Application Ref:	3/2025/0874			 Ribble Valley Borough Council www.ribblevalley.gov.uk				
Date Inspected:	28/01/26	Site Notice:	28/01/26					
Officer:	LW							
DELEGATED ITEM FILE REPORT:					APPROVAL

Development Description:	Proposed first floor extension, balcony and front porch.
Site Address/Location:	Woodlands Farm, Hothersall Lane, Hothersall, PR3 2XB.

SHEET:
**PROPOSED PLANS &
ELEVATIONS**

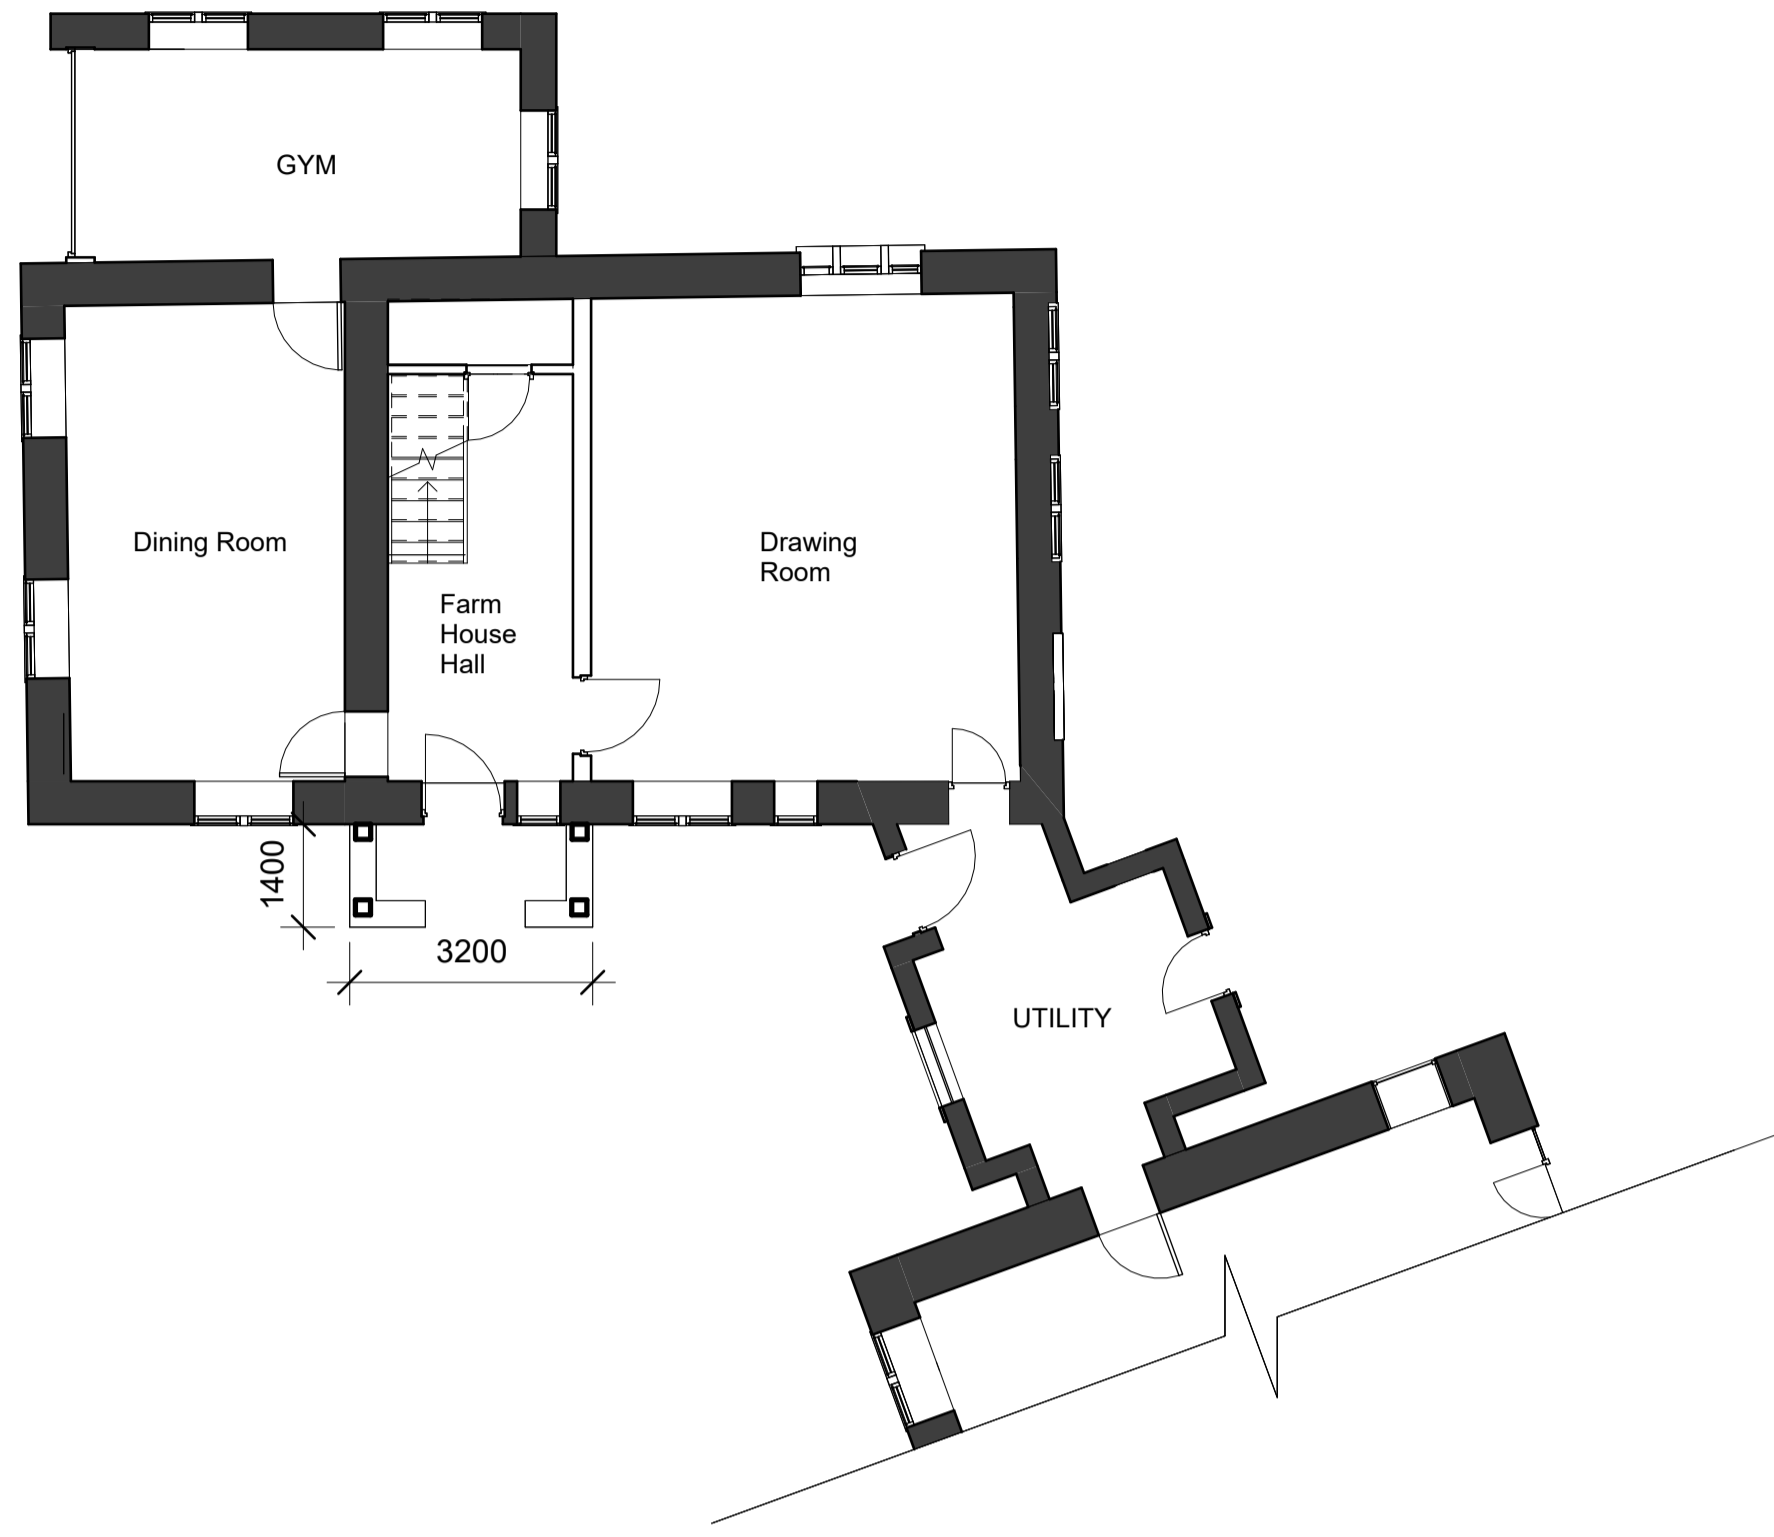
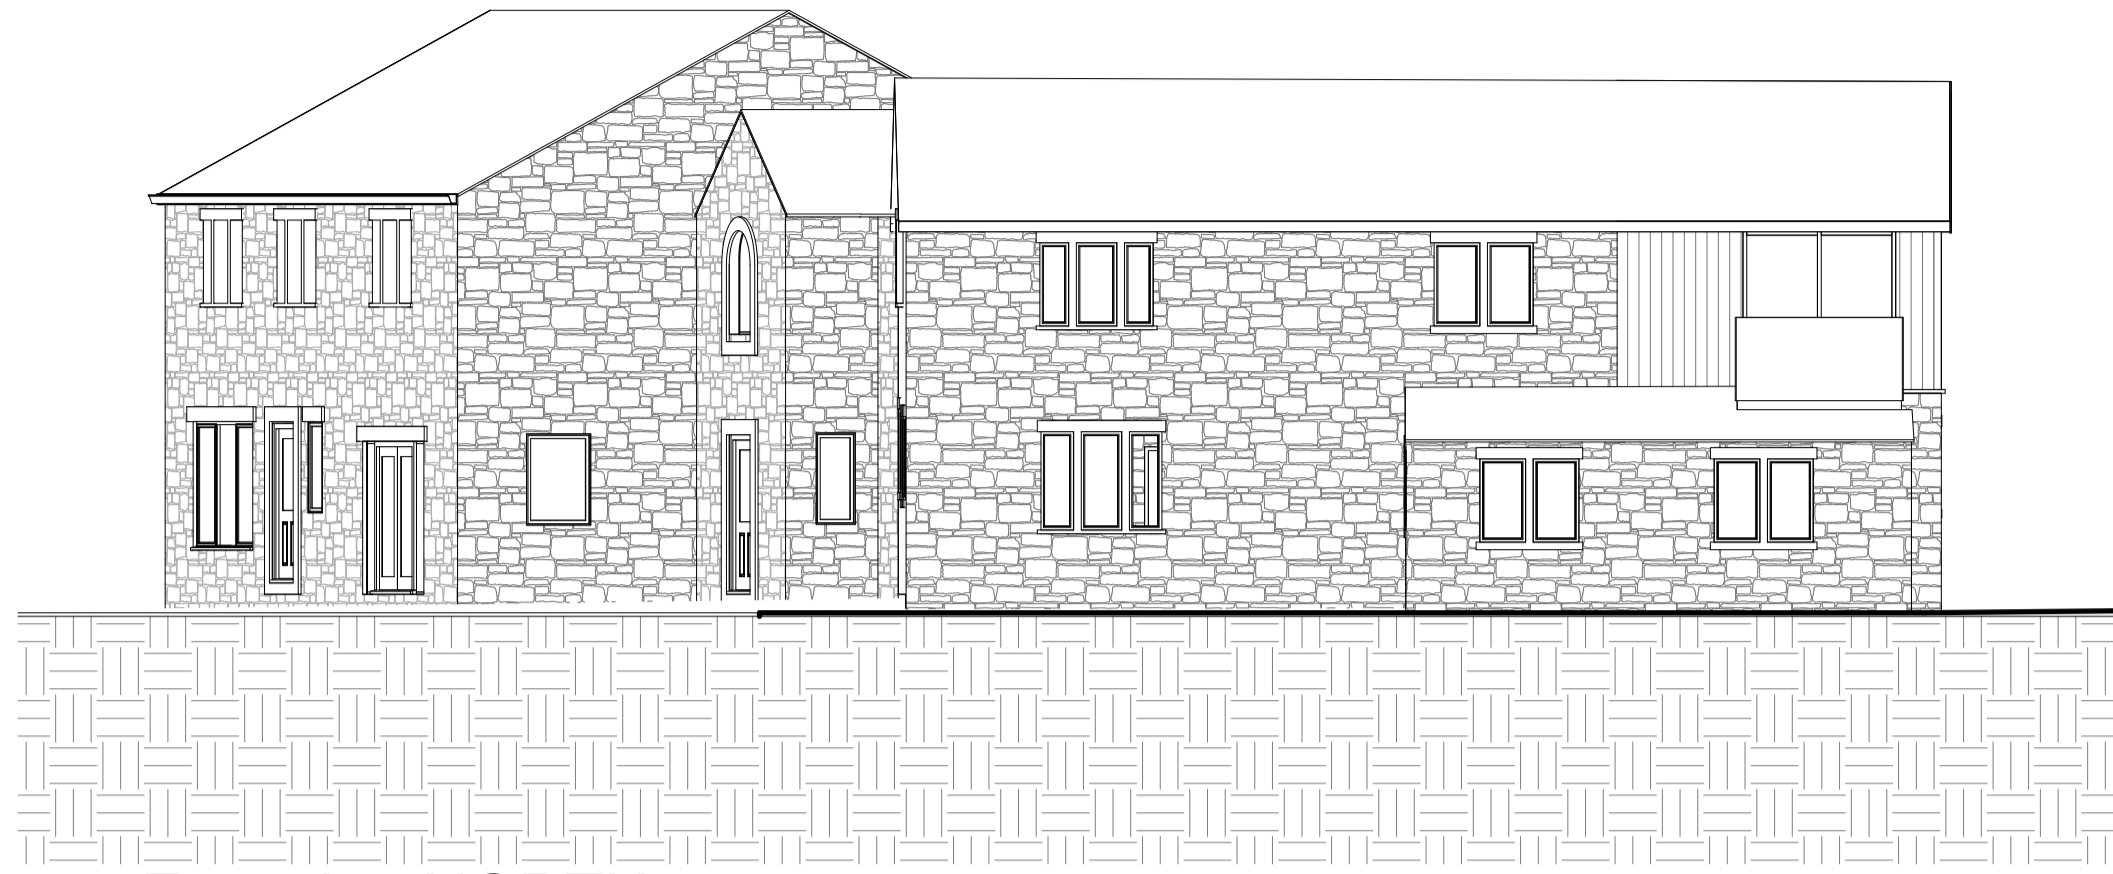
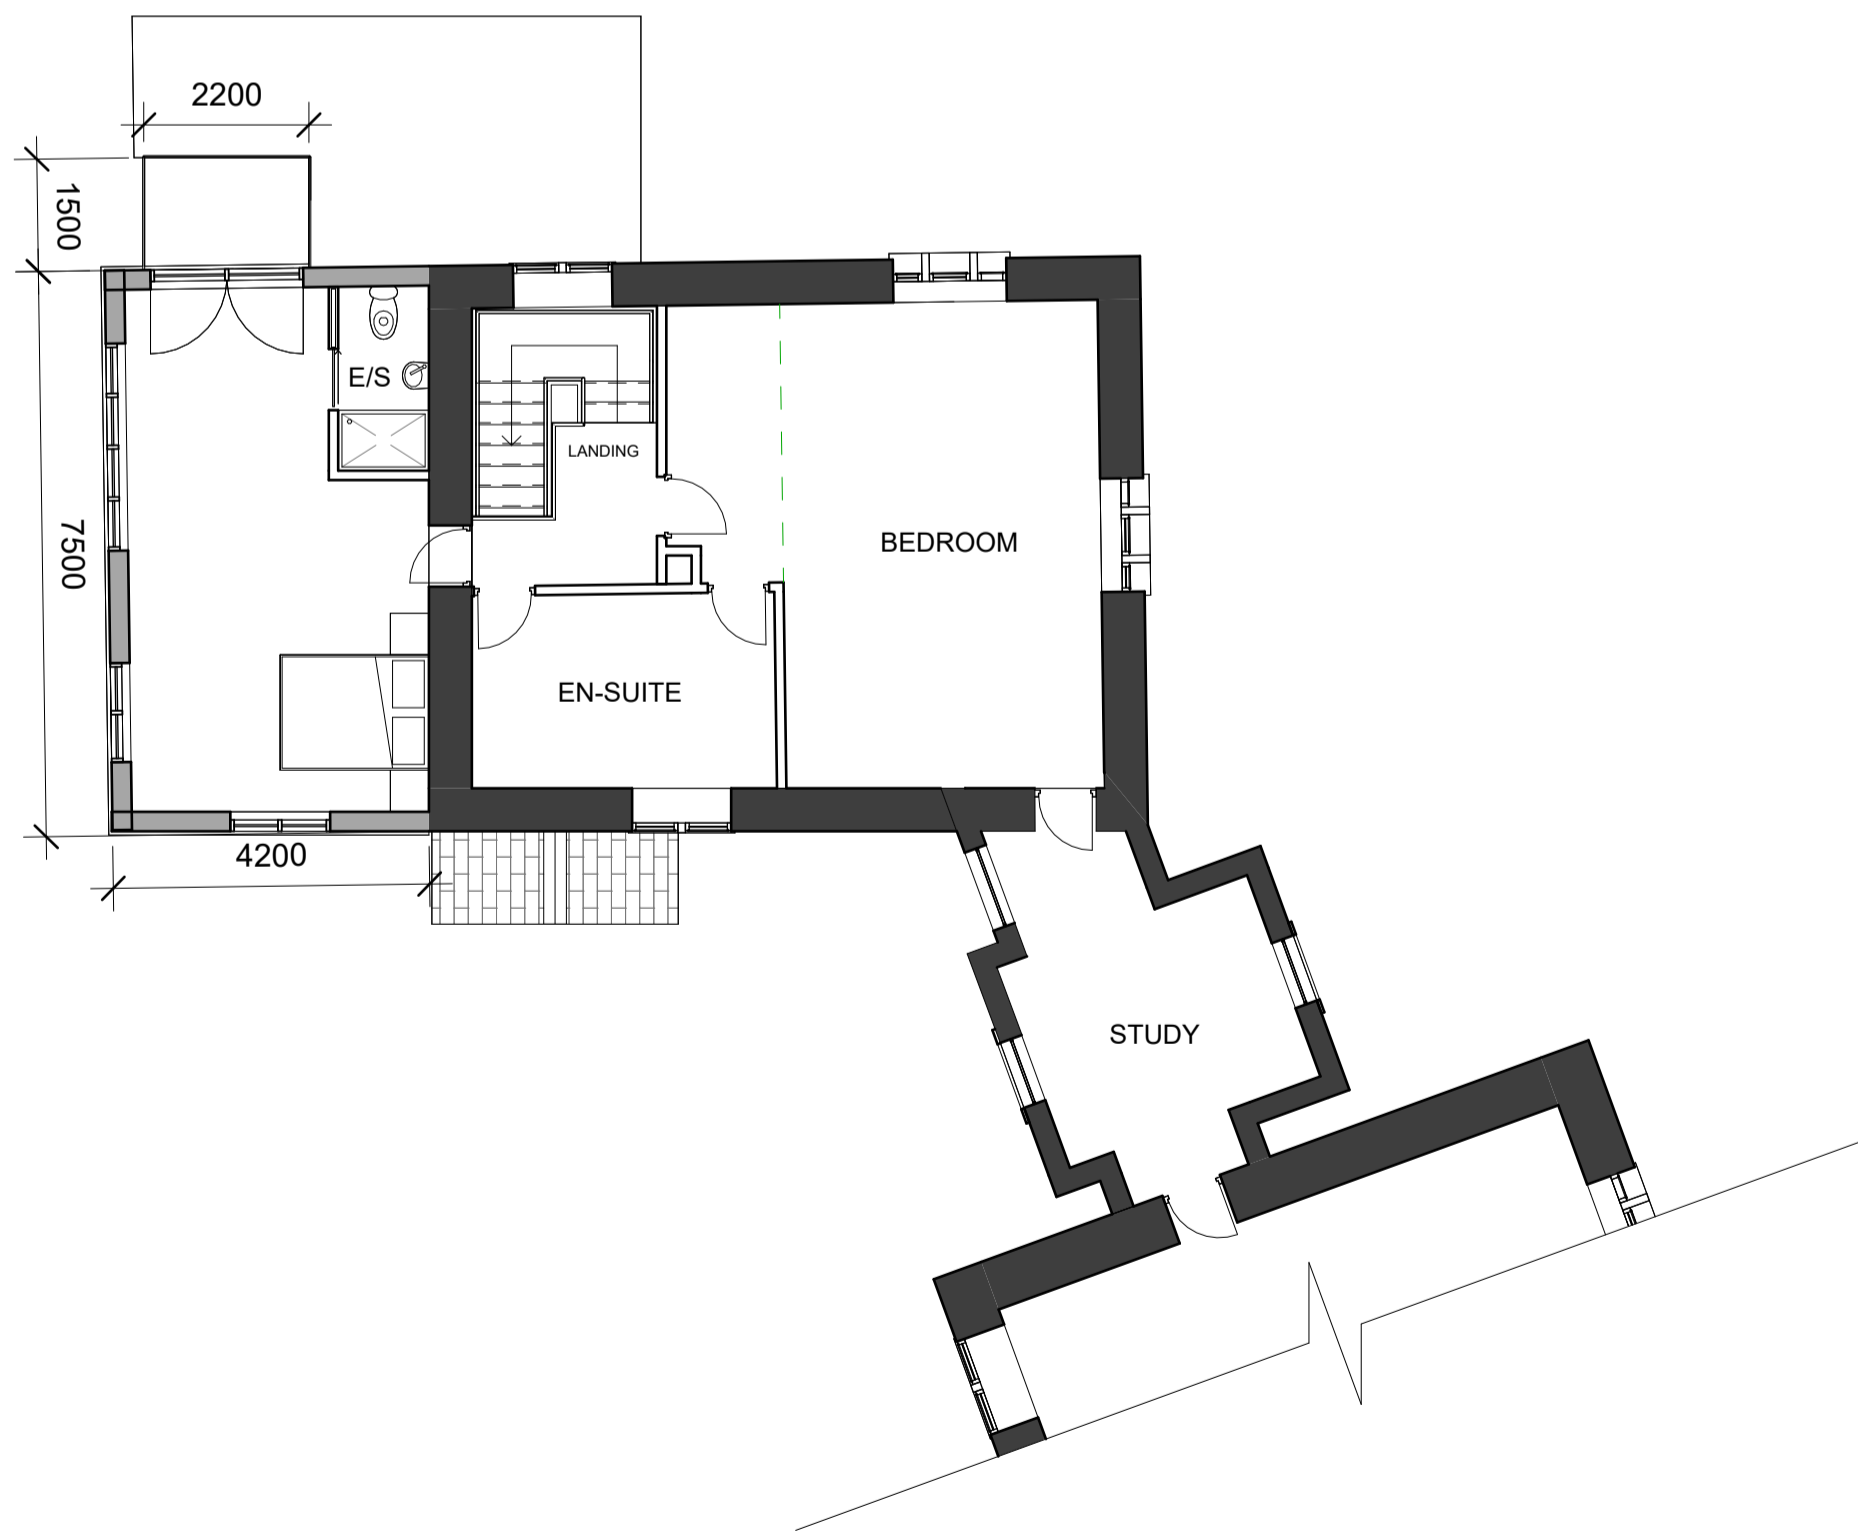
The proposed first floor extension would be located above the existing single storey lean-to structure featured to the north-western elevation of the property and would measure 4.2m by 7.5m with an eaves and ridge height of 4.9m and 6.8m respectively. To the north-eastern facing elevation of the extension, a new balcony is proposed, measuring 2.2m by 1.5m, which would be accessed via double doors. Additional window openings are also proposed to the north-western and south-western elevations of the extension. The development would incorporate vertical timber cladding to the walls, along with slate roof tiles and timber framed openings.

The front porch proposed to the south-western elevation of the property would measure 3.2m by 1.4m with an eaves height of 2.2m and ridge height of 3.3m. The development would be open sided, comprising low stone walling and a slate roof.

In most cases, the Local Planning Authority would seek to ensure that first floor extensions are adequately set down from the main ridgeline so as to ensure that the proposal appears subservient to the main property. On this occasion, the proposed extension would be flush with the ridge of the existing two-storey dwellinghouse. However, given the siting/ orientation of the proposal as well as the existing built form of the application property, it is not considered that the lack of set down for the proposed extension would result in an incongruous addition that would be unduly harmful to the application dwelling or surrounding area in this particular instance. In addition to this, the degree of projection from the north-western gable elevation would not be significant when read in context with the existing built form of property and therefore no concerns are raised in this respect.

It is noted that the proposed first floor extension would utilise timber cladding to the external elevations which would not match the existing stone built dwellinghouse. However, given the location of the development towards the rear of the property and the relatively limited usage of timber cladding when viewed in context with the existing stonework, it is not considered that the proposed materiality would significantly detract from the existing character and visual amenities of the dwellinghouse to a degree which would warrant the refusal to grant planning permission. The use of timber cladding would also go some way to ensure that the proposal reads as a later addition to the dwellinghouse, ensuring a visual separation between the old and the new, whilst the incorporation of slate roof tiles and timber windows would mean that the addition retains some visual similarity to the parent building. On balance, the proposed materiality of the extension is therefore considered acceptable in this particular instance.

The proposed balcony would not be afforded a high level of visibility from the adjacent public realm, being screened from view by the dwellinghouse itself and would comprise a relatively modest addition to the property. The proposed porch would also be of a size, scale and design which would remain in keeping with the existing dwellinghouse. As such, no concerns are raised in this respect.
